**DELEGATED LISTED BUILDING DECISION**

**Address:** CANNONS BRIDGE FARM BURY STREET RUISLIP

**Development:** Replacement of existing single glazed windows of the listed dwelling with a mixture of timber/metal framed double glazed replacements.

**LBH Ref Nos:** 35387/APP/2023/3371

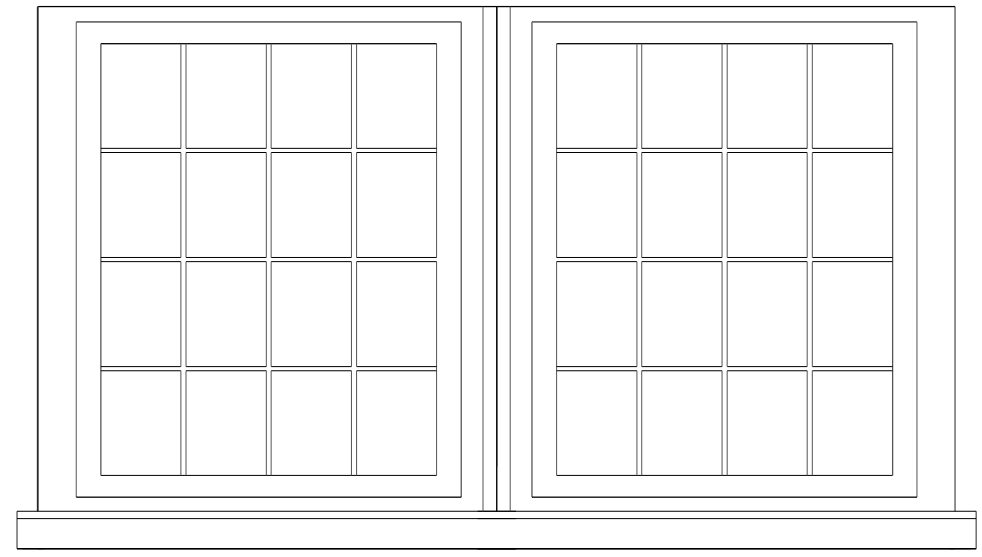
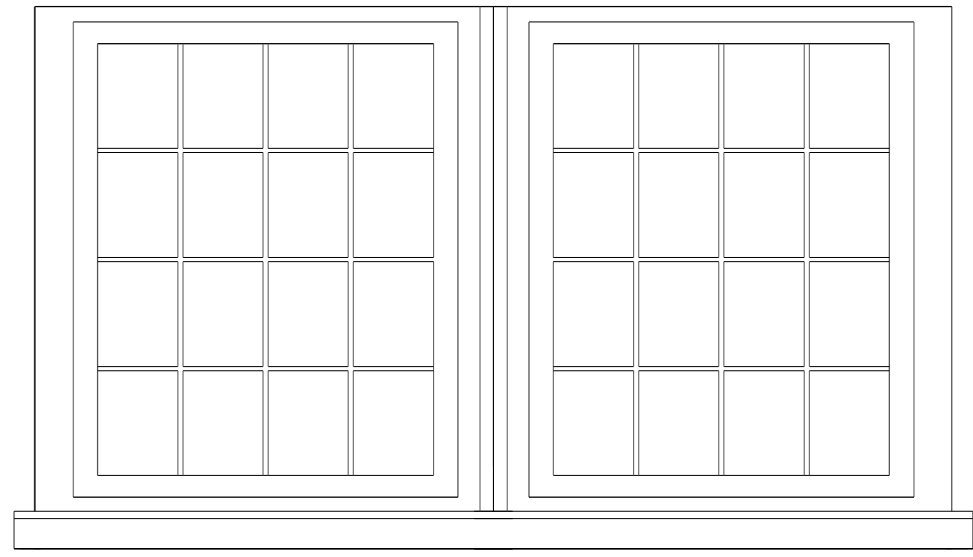
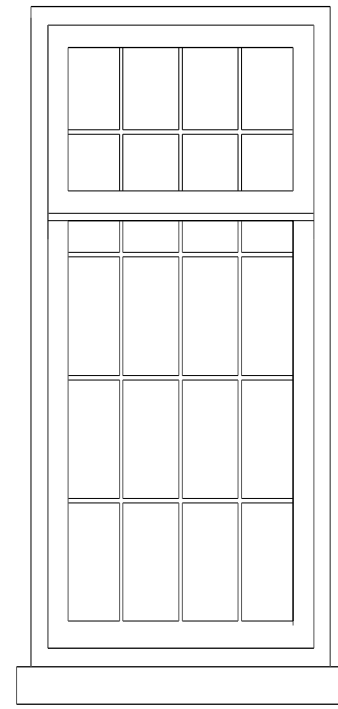
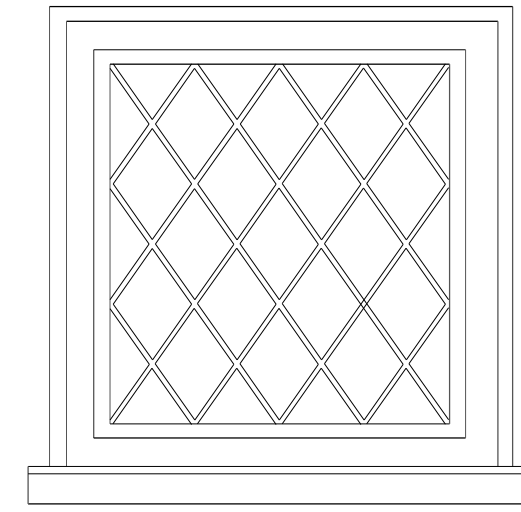
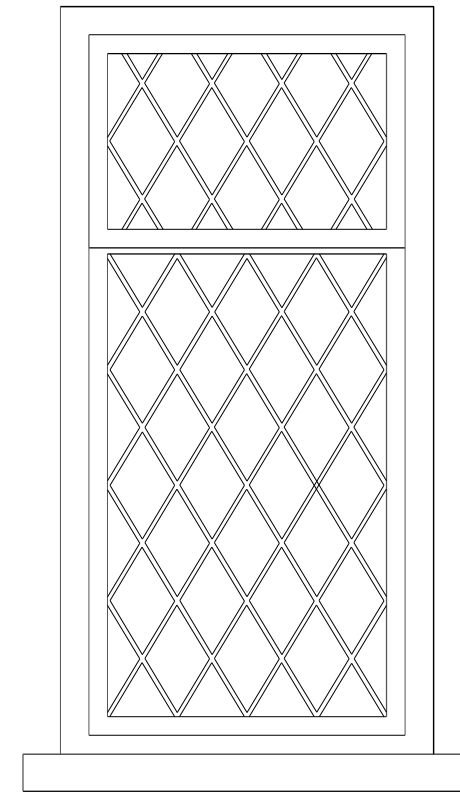
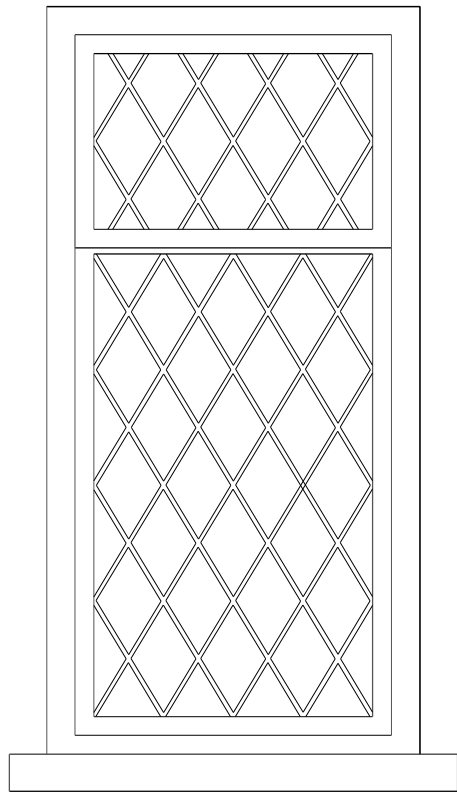
The drawings are confusing as 005 & 006 are described as proposed and show leaded lights. While the Heritage Statement, supported by drawing 008, states that the proposed windows will be the same windows as those approved by condition for the new extension, Alitherm, aluminium 24mm double glazed windows (which are single pane).

The Alitherm windows would not be supported as they would not preserve the Arts & Crafts or historic character of the listed building and 24mm double glazed units are considered unsuitable for the historic building.

What is needed to ensure that the Arts & Crafts character is preserved are metal frame, slimline double glazing (less than 12mm in depth) with leaded lights. It is recognised that the leaded lights would not be integrated with the units but on balance it would better preserve the architectural interest of the building.
